East Anglia ONE North and East Anglia TWO Offshore Windfarms

Applicants' Comments SASES Deadline 8 Submissions

Applicant: East Anglia TWO and East Anglia ONE North Limited
Document Reference: ExA.AS-9.D9.V1
SPR Reference: EA1N_EA2-DWF-ENV-REP-IBR-001038

Date: 15th April 2021
Revision: Version 1
Author: Royal HaskoningDHV

DRG No.	ED11892-C-SK10	REV	G
DRG SIZE	A3	SCALE	NTS
DATE	SEPT'20	APPROVED BY	SH
DRAWN BY	JN	CHECKED BY	CS

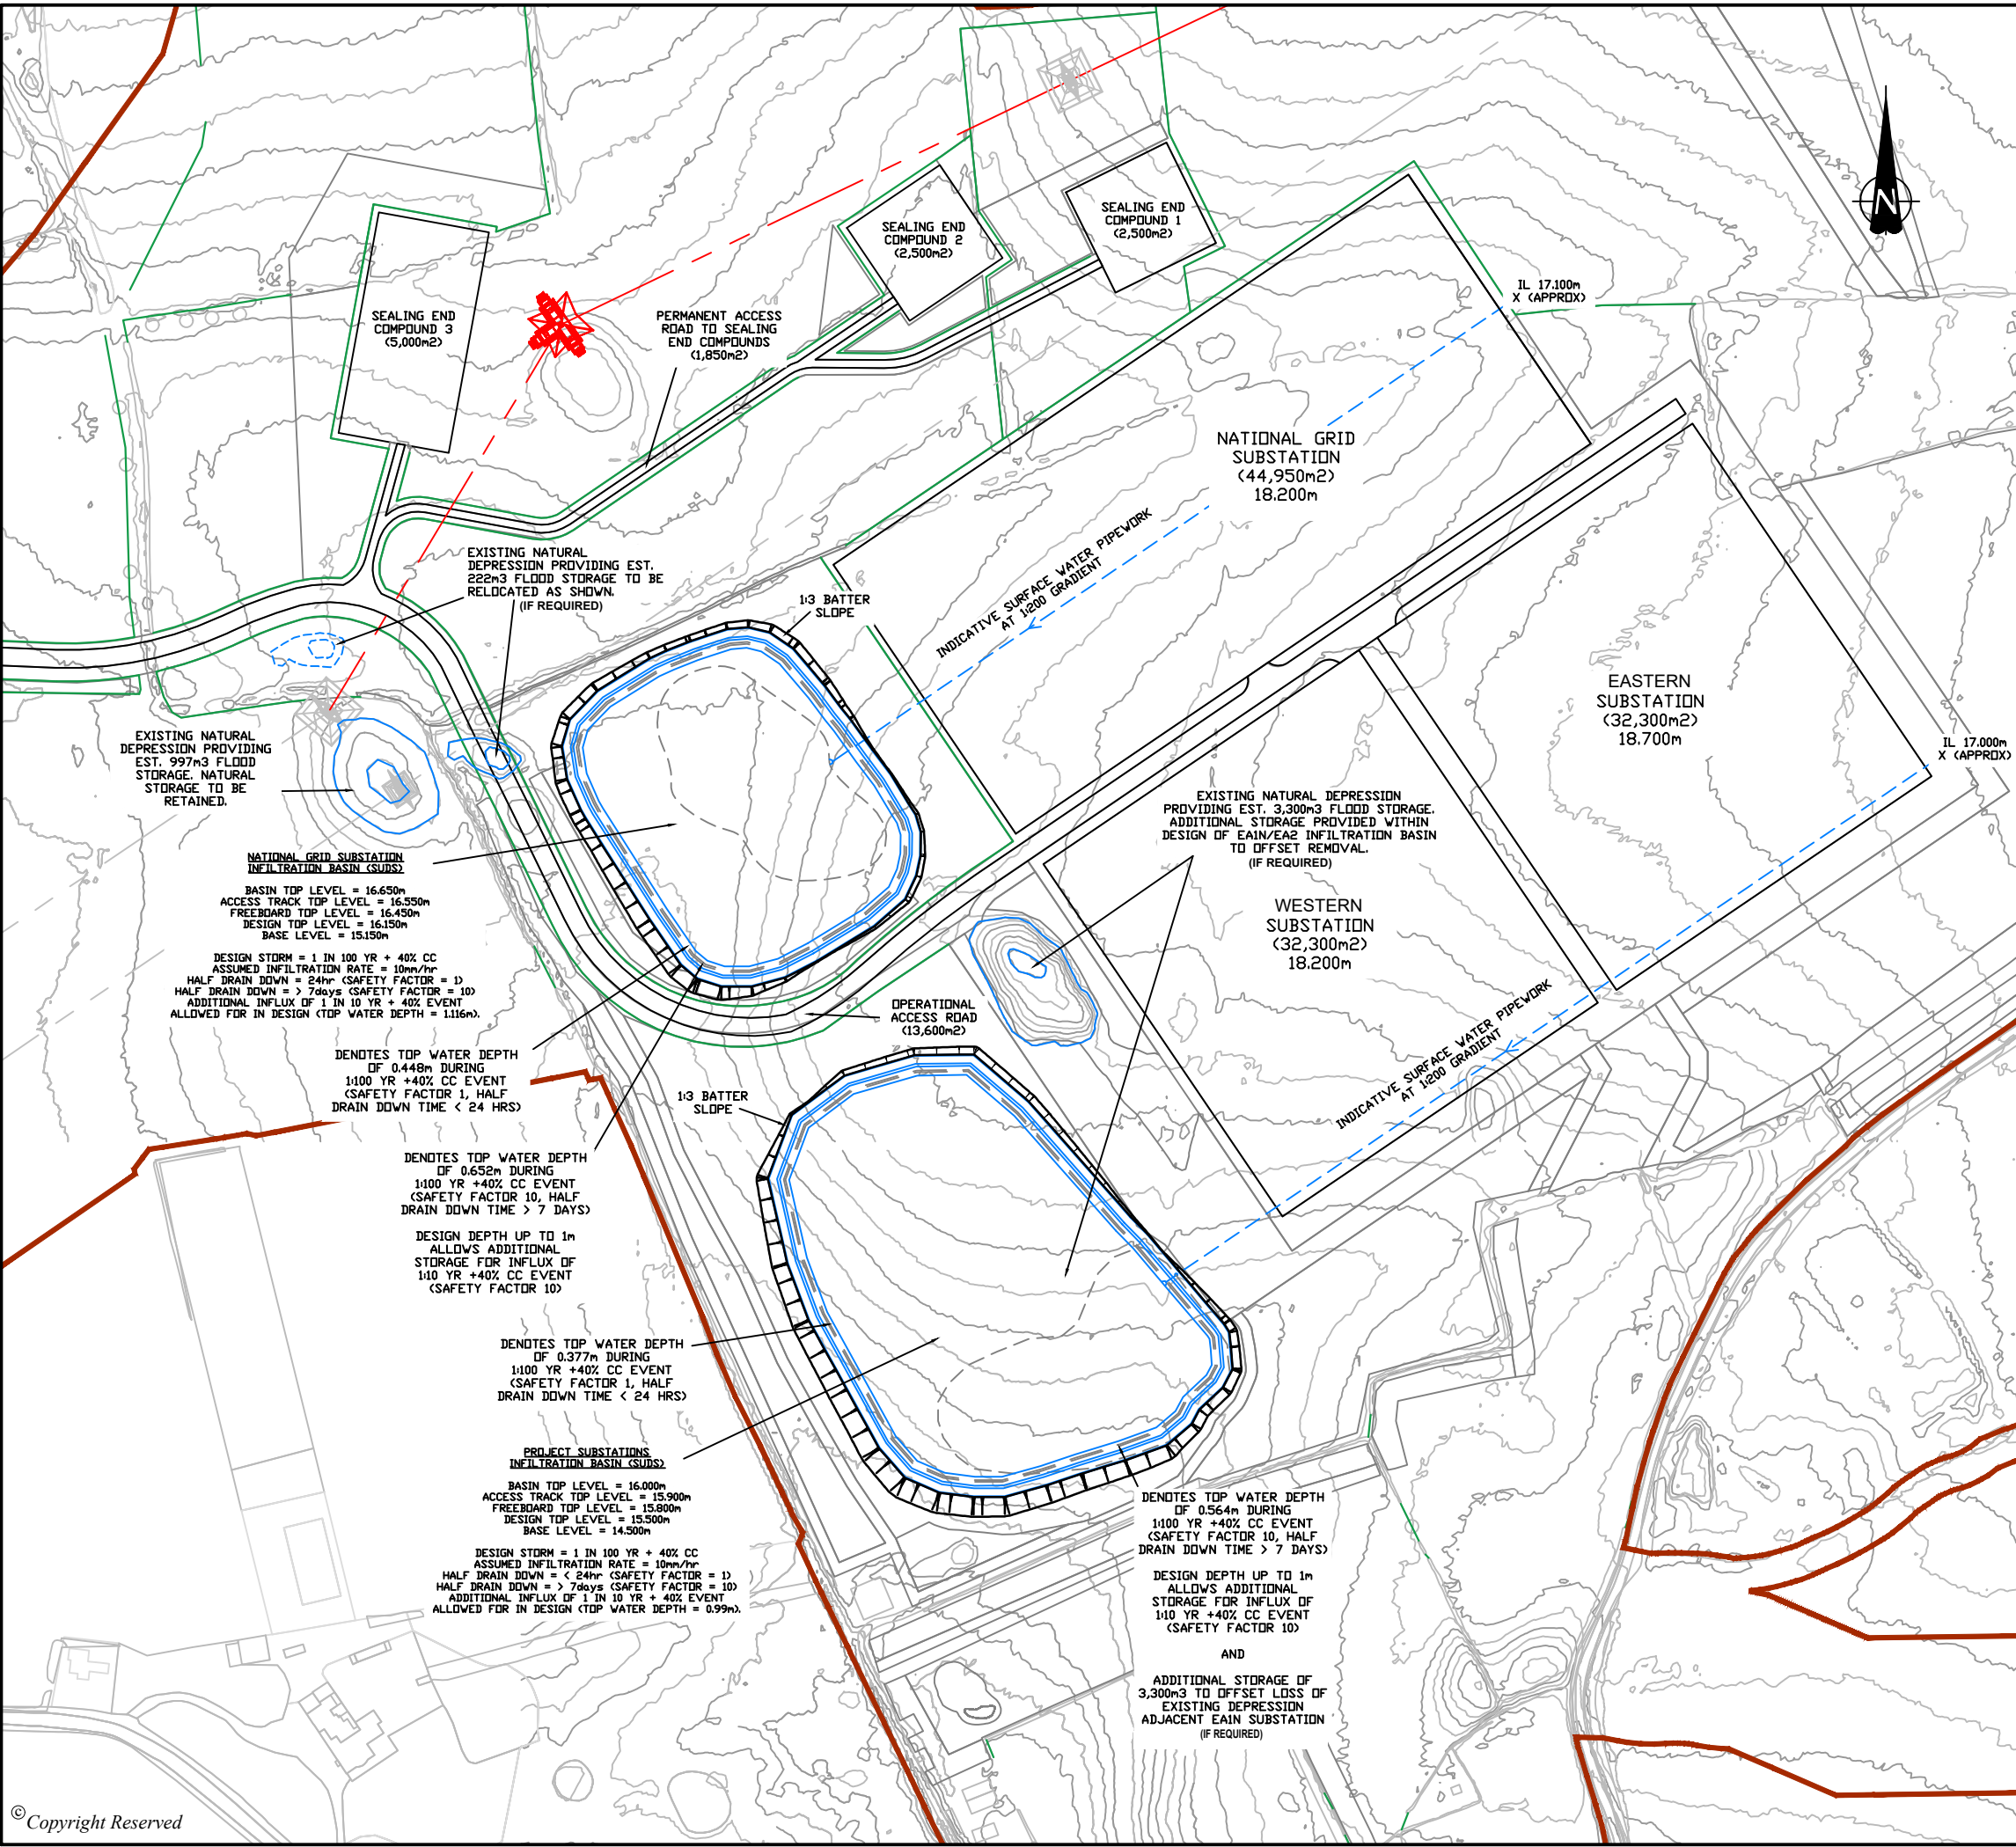
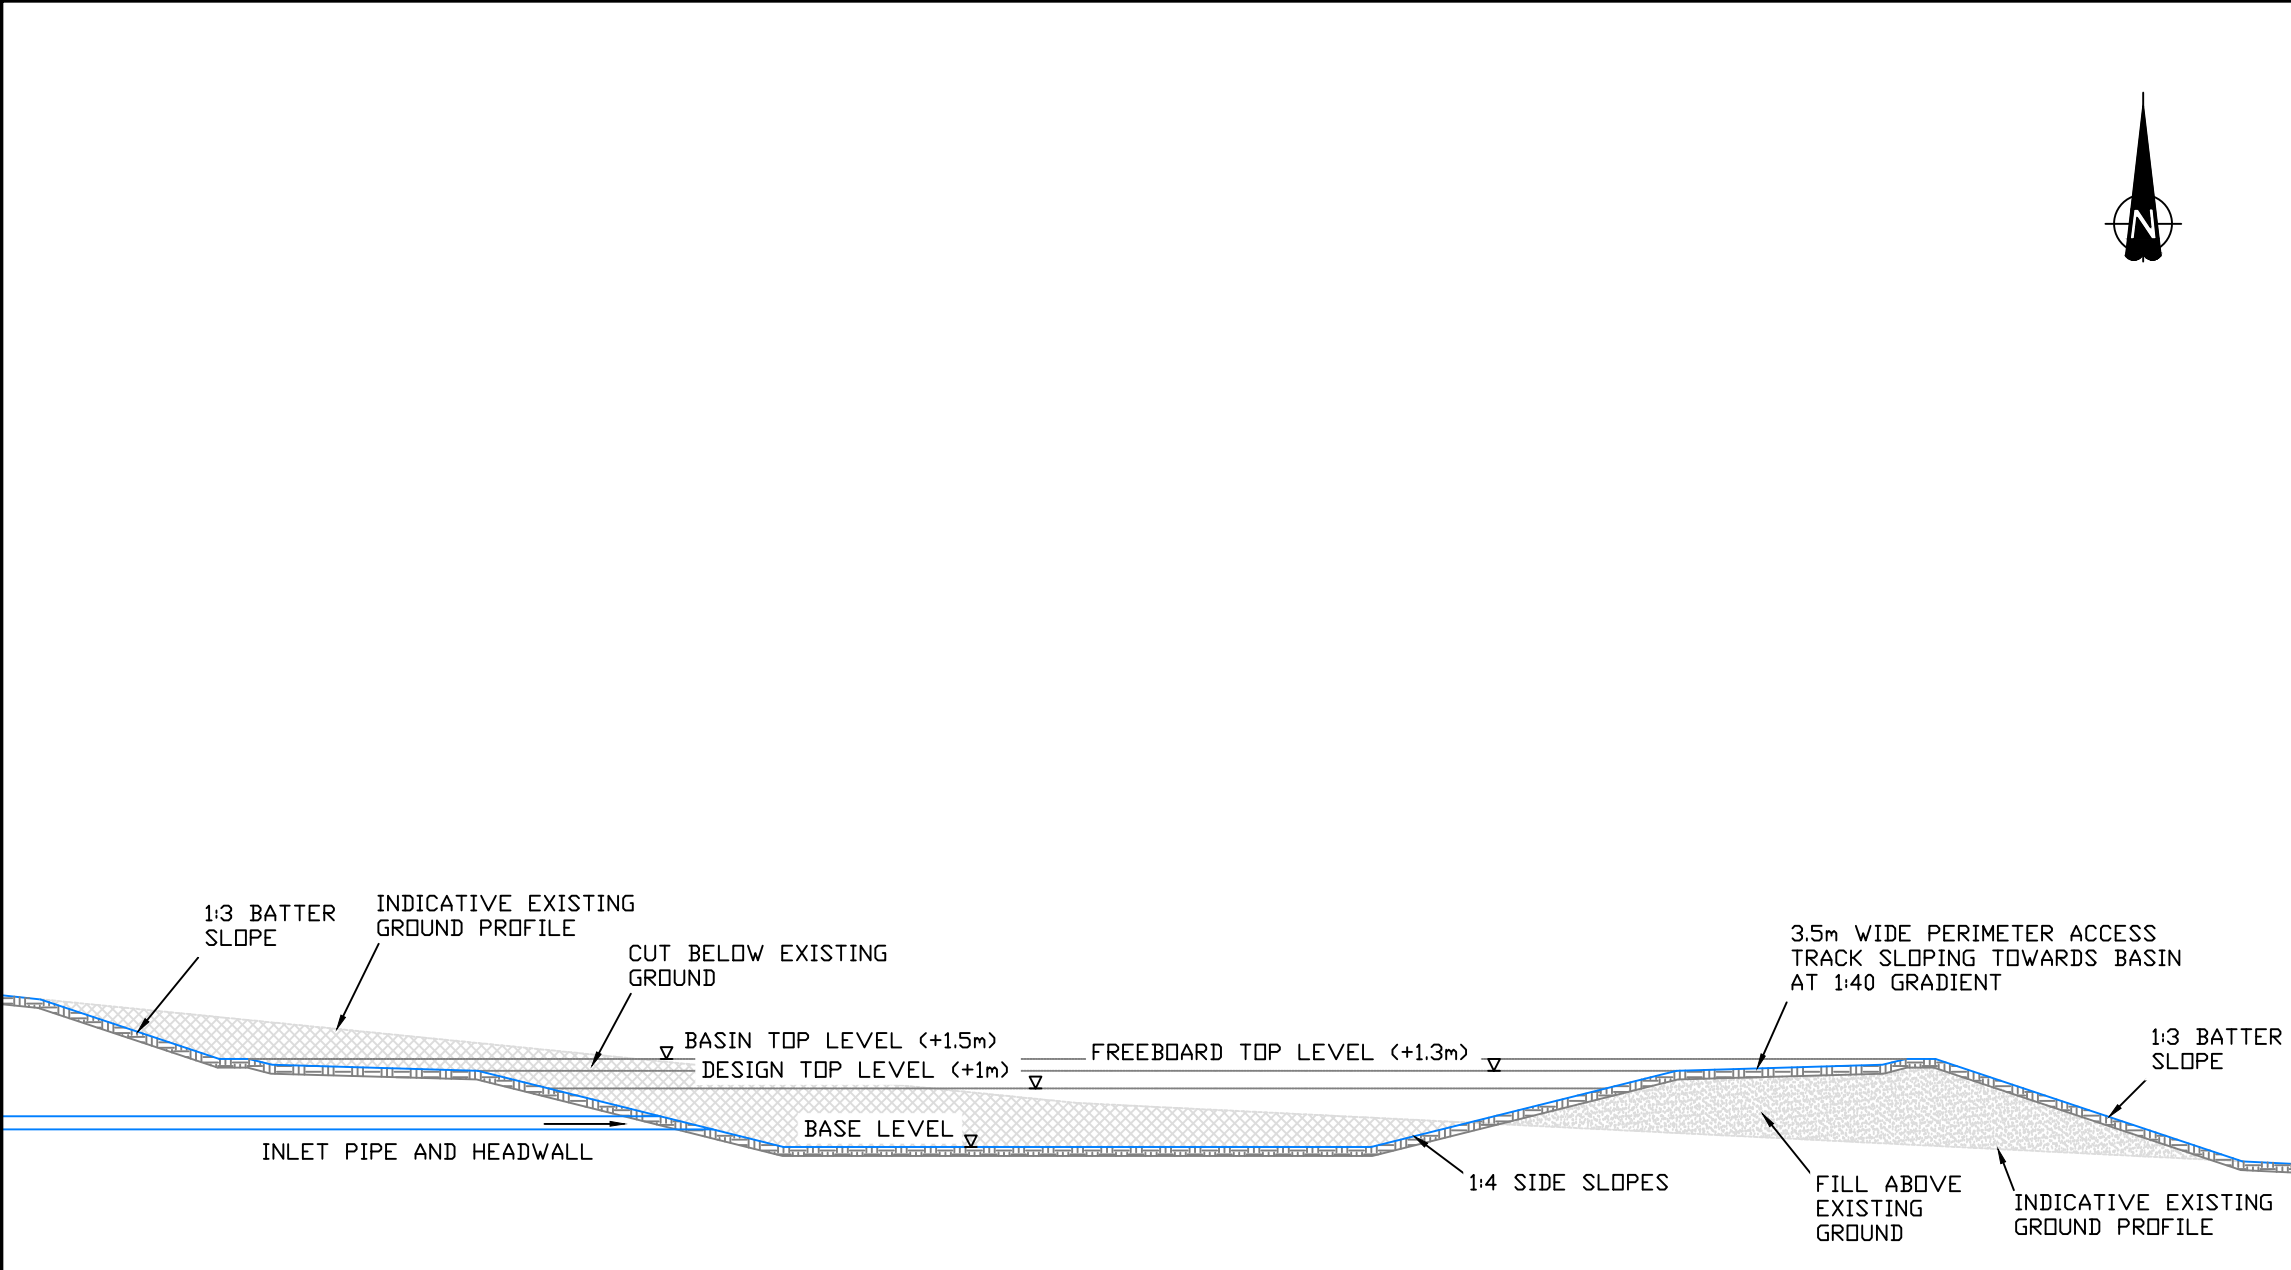
ID	SASES' Comment	Applicants' Comments
Implications of Latest Infiltration Basin Proposals		
1	The latest Outline Operational Drainage Management Plan (Outline Operational Drainage Management Plan - Version 03 24/02/21 REP6-017) includes a sketch figure showing an Option for infiltration basins (Wardell Armstrong Dwg ED11892-C-SK10 Infiltration Basin 10mm Per Hour Options Sketch)	The Applicants confirm this is correct.
2	Figure 16 SUDS Overlay attached to this Briefing Note overlays Dwg ED11892-C-SK10 (Outline Operational Drainage Management Plan - Version 03 24/02/21 REP6-017) on the latest OLMP Proposed Planting Plan (Figure 6 in Outline Landscape and Ecological Management Strategy (OLMP) V03 24/02/21 REP6-007) [figure found here https://infrastructure.planninginspectorate.gov.uk/wp-content/uploads/projects/EN010078/EN010078-004656-sases%20appendix%203%20to%20ISH%2011%20submission.pdf]	The Applicants note Figure 16.

3	From Figure 16 it can be seen that the infiltration basins are considerably larger than the basins shown on the OLMP Proposed Planting Plan and would have the following consequences for the planting: <ul style="list-style-type: none"> • The triangular area of mitigation woodland located to the south west of the northern basin would have to be omitted. • Whilst a small strip of planting could be accommodated to the west of the northern basin it would need to allow access to the 	The Applicants would note that they do not intend to develop the infiltration basins shown on Figure 16, in part for the reasons highlighted by SASES. For clarity, the figure in Appendix 2 of the OODMP (REP8-064), which was used to create Figure 16, is indicative and was produced to demonstrate the basin sizes required for an infiltration only scheme based on a highly conservative infiltration rate. Other potential drainage options were additionally presented in the OODMP (REP8-064), however these have not been overlaid by SASES. The SuDS basins shown on the Outline Landscape Mitigation Plan (OLMP) presented within the Outline Landscape and Ecological Management

4	<p>The OLMP Proposed Planting Plan shows areas of tree planting within the infiltration basins. It is unclear why these have been introduced as they will require an overall enlargement of the area of infiltration basins. It is questionable whether trees in these locations and close to the edge of the basins would be compatible with the engineered structures of the Infiltration basins.</p>	<p>Please see response at ID3.</p>
5	<p>The OLMP V03 (REP6-007) was issued on the same date as the Outline Operational Drainage Management Plan - Version 03 (REP6-017) but does not reflect the proposed enlargement of the basins. This suggests that the landscape implications of enlarging the basins have not yet been considered.</p>	<p>Please see response at ID3.</p>
6	<p>The removal of the woodland from the southern and western edges of the northern infiltration basin will limit the effectiveness of the proposed mitigation in views from Footpath 17 which is located to the west of the proposed infiltration basins. The only LVIA Vp from Fp 17 is Vp 1. The grassed bund visible in the visualisation from Vp</p>	<p>Please see response at ID3.</p>

ID	SASES' Comment	Applicants' Comments
	<p>embankments for maintenance purposes and would be constrained by the access road.</p> <ul style="list-style-type: none"> Access to the embankments for maintenance purposes would reduce the area for woodland planting along the southern and western edges of the southern basin. <p>[figure found here https://infrastructure.planninginspectorate.gov.uk/wp-content/uploads/projects/EN010078/EN010078-004656-sases%20appendix%203%20to%20ISH%2011%20submission.pdf]</p>	<p>Strategy (OLEMS) (REP8-019) are based on the attenuation only scheme as described in the OODMP (REP8-064). As clearly stated in the OODMP (REP8-064) the Applicants intend to develop a SuDS that utilises the maximum amount of infiltration possible without increasing the basins footprints shown on the OLMP, whilst also considering factors such as landscape planting and ecological receptors.</p>
